**RE: Lot 15 Block 6 Unit 2 Unser Cliffs SAD 227
8023 Victoria NW
Grading and Drainage Plan
Engineers Stamp Date 10/18/17 (E10D040)**

Based upon the information provided in your submittal received 10/19/17, this plan is approved for Grading Permit.

ENGINEER'S SEAL  10/18/17 10/16/17	8023 VICTORIA DRIVE, N.W.	DRAWN BY WCMJ
	GRADING AND DRAINAGE PLAN  <i>Rio Grande Engineering</i> 1606 CENTRAL AVENUE SE SUITE 201 ALBUQUERQUE, NM 87106 (505) 872-0999	DATE 10-15-17
DAVID SOULE P.E. #14522		21810-LAYOUT-10-16-17
		SHEET # —
		JOB # 21810

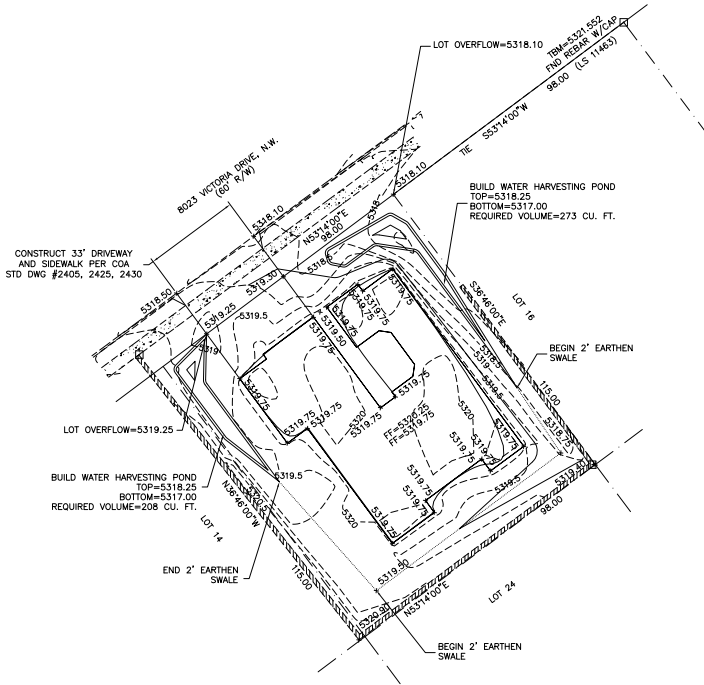
- Provide a statement on the plan stating that this grading plan must be submitted for the application of any garden/retaining walls.

ADDED
